From: Michael Eastham
Sent: 16 January 2018 13:43
To: Planning.Responses
Cc: Lisa Coney; Nicola Spencer
Subject: FW: Swanbourne Park - AL/82/12 - LEAP/LAP Proposals

Thank you for submitting LAP and LEAP proposals dwg BSH17576 31 A

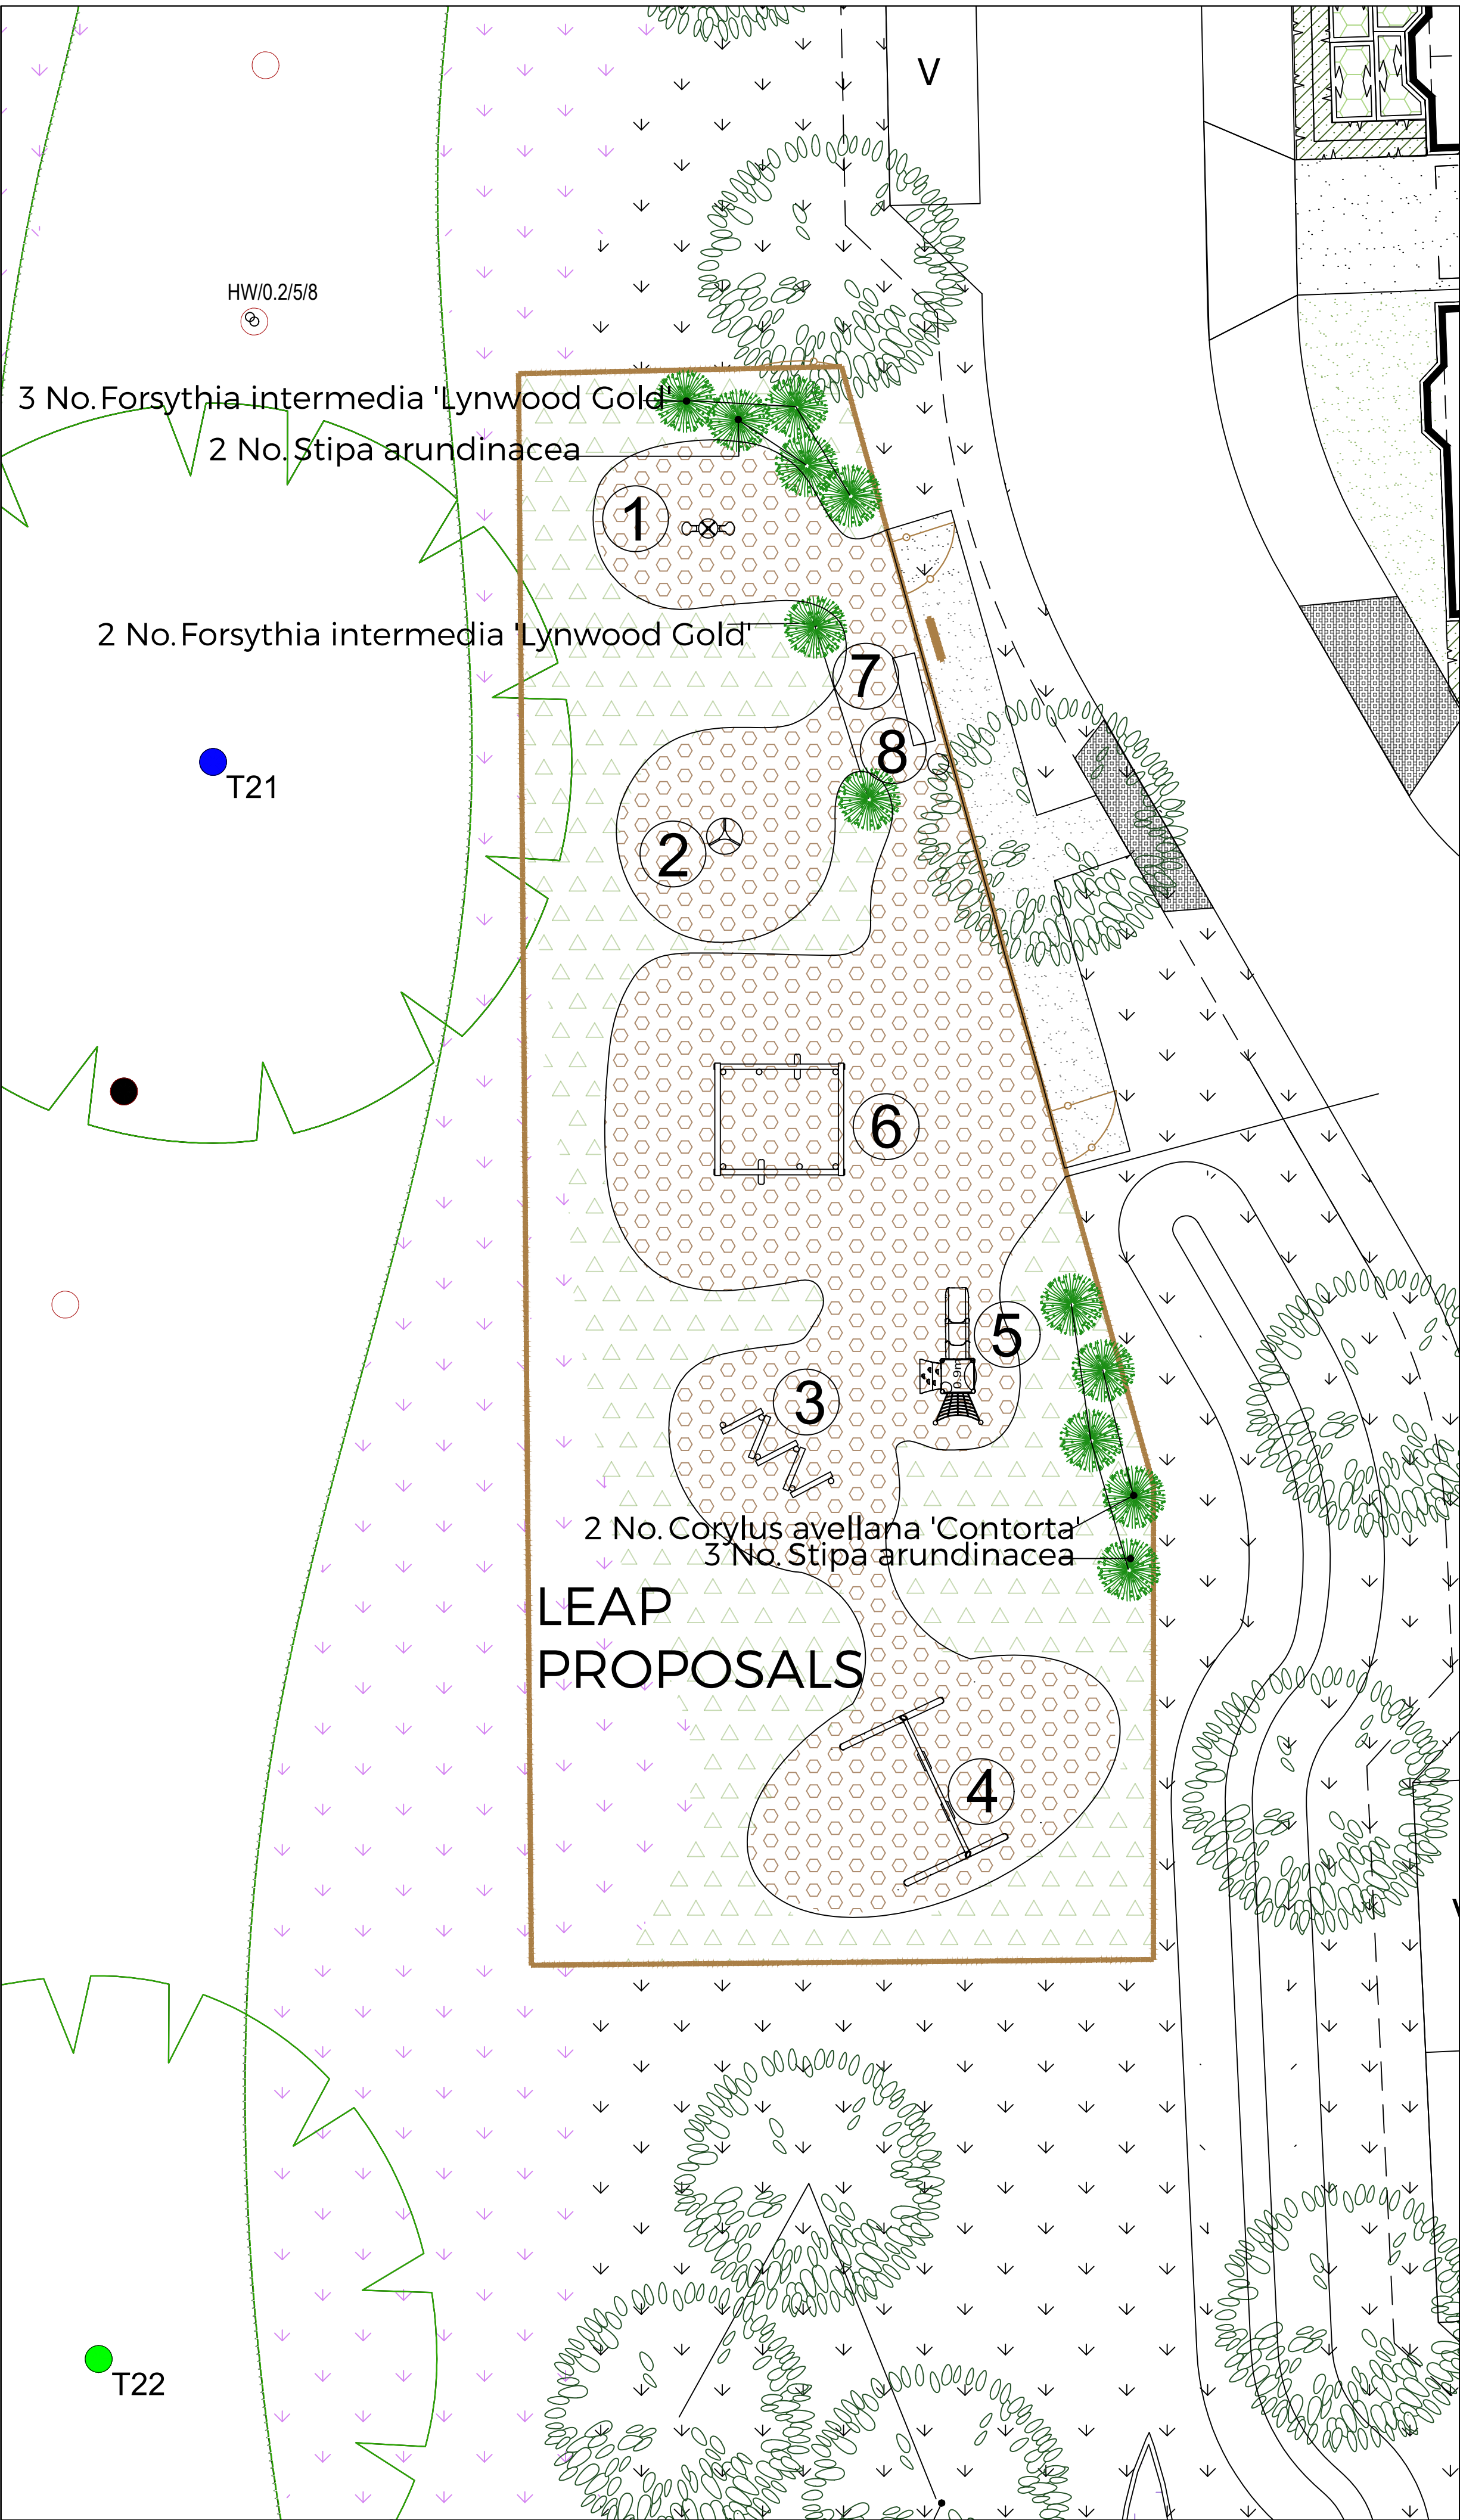
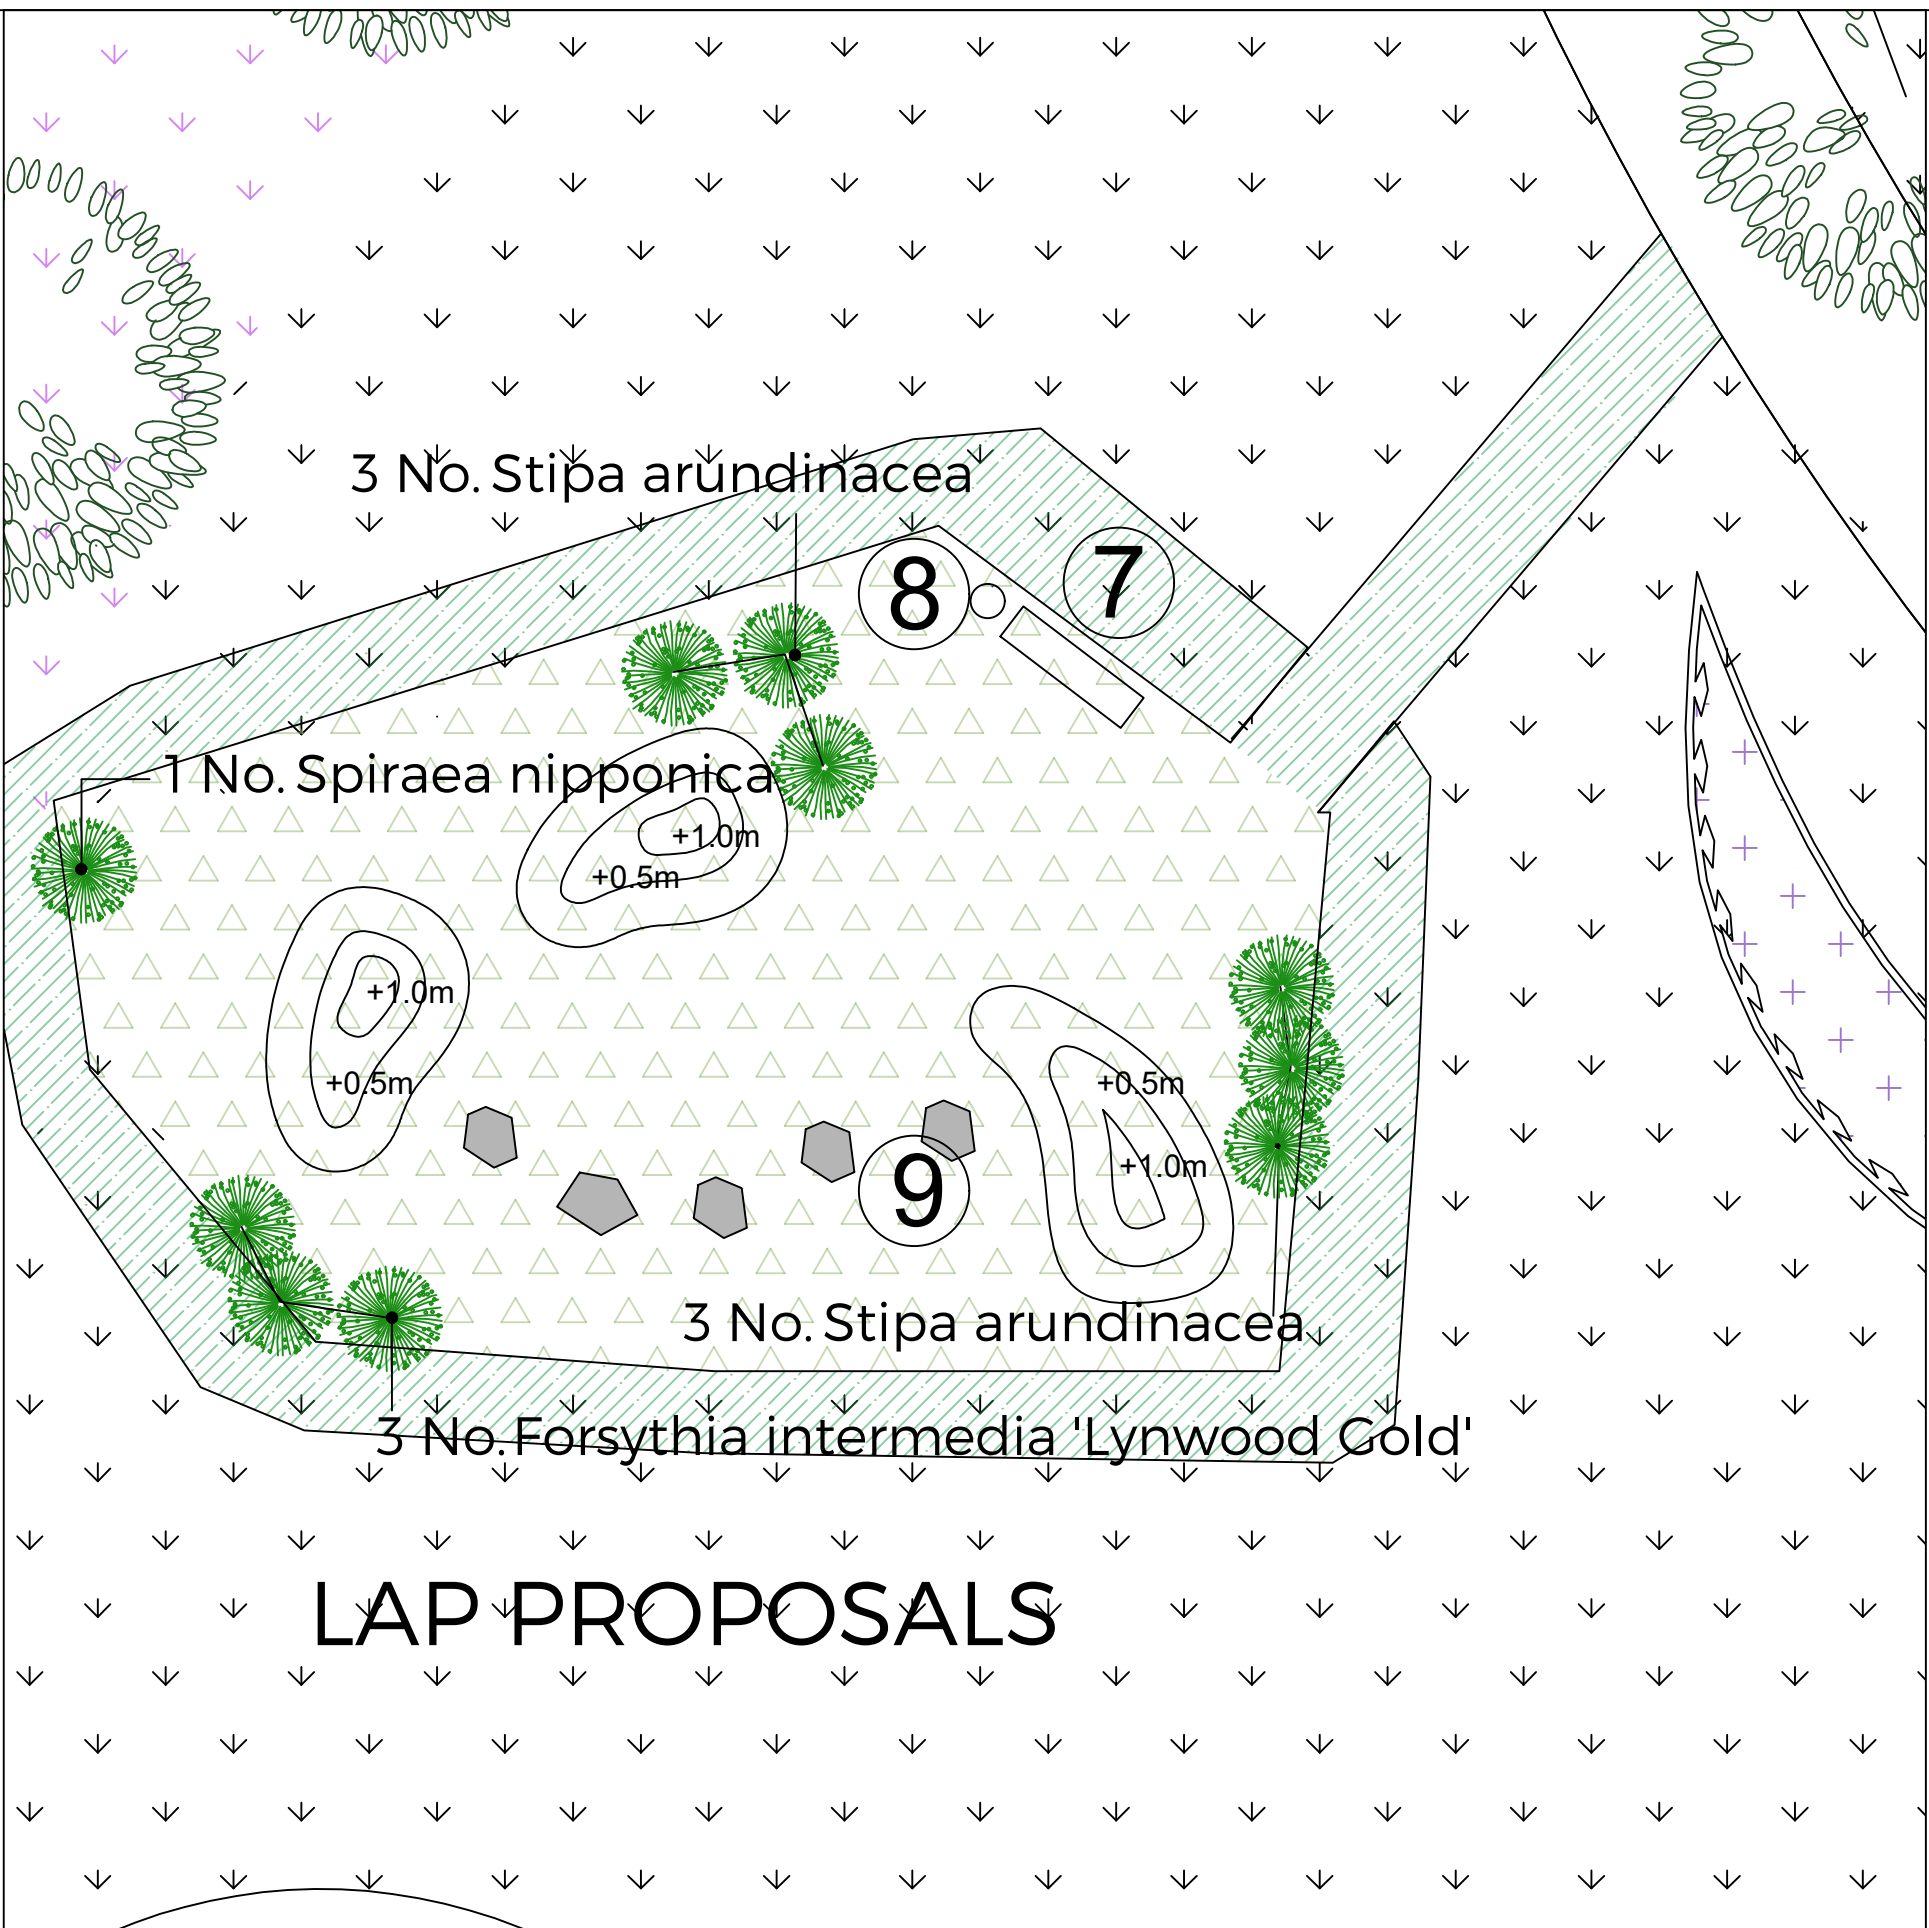
LEAP Needs to provide a minimum of six experiences and be designed and laid out specifically for children who are beginning to go out and play independently. This should provide stimulating and challenging play experiences. I do not believe that the offer being presented caters for this criteria, therefore please reassess the offer here, amend and re-submit. Gates when incorporated into a fenced areas are better to be accessed via pathways to make these more user/wear friendly. Please detail fence type where indicated for fencing.

LAP This should be a small area of open space – Not fenced specifically designated and primarily laid out for very young children to play close to where they live. This we do not need to see equipped but to have some natural play experience ie mounds, boulders natural play. The provision of a seat in this area is still acceptable. Please remove formal fenced and tarmac detail, amend and resubmit.

I have instructed a revised design to be generated on the attached mark-up. The LAP design will significantly change and reflect a more natural play area.

The LEAP area has been designed with 5 pieces of equipment, each focusing on a different movement (swinging, spinning, sliding etc.). We are proposing to keep these and add a piece of equipment to focus on the climbing movement. I have attached a picture of the piece of equipment for consideration. This will be centred in the LEAP area as it is larger than the other items. The fence type is 1m galvanized bowtop fence in black – legend/key specifies this.
